Site 68 Mixed Used Development, Sydney Olympic Park (SSD 6603) – Response to Submissions

**Site 68 Mixed Use Development, Sydney Olympic Park (SSD 6603)
Comments on the Proposal and Conditions of Consent**

Section through Wintergarden facade with glazing open

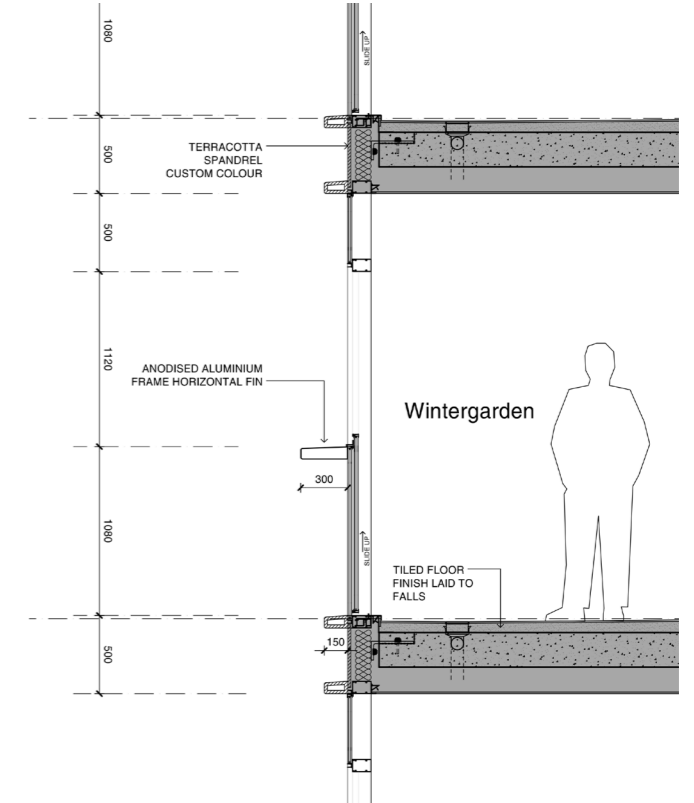
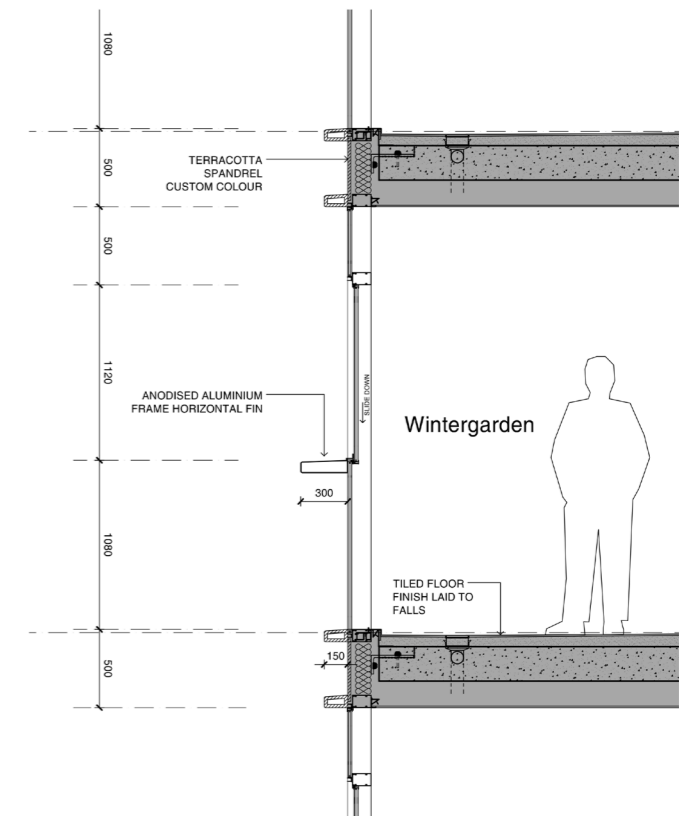
- landscape plan details shall be provided of the proposed winder gardens;
- mitigation measures to minimise potential conflicts between service vehicles and other vehicles entering the basement, due to the location of the basement loading dock immediately adjacent to the basement car park entrance;
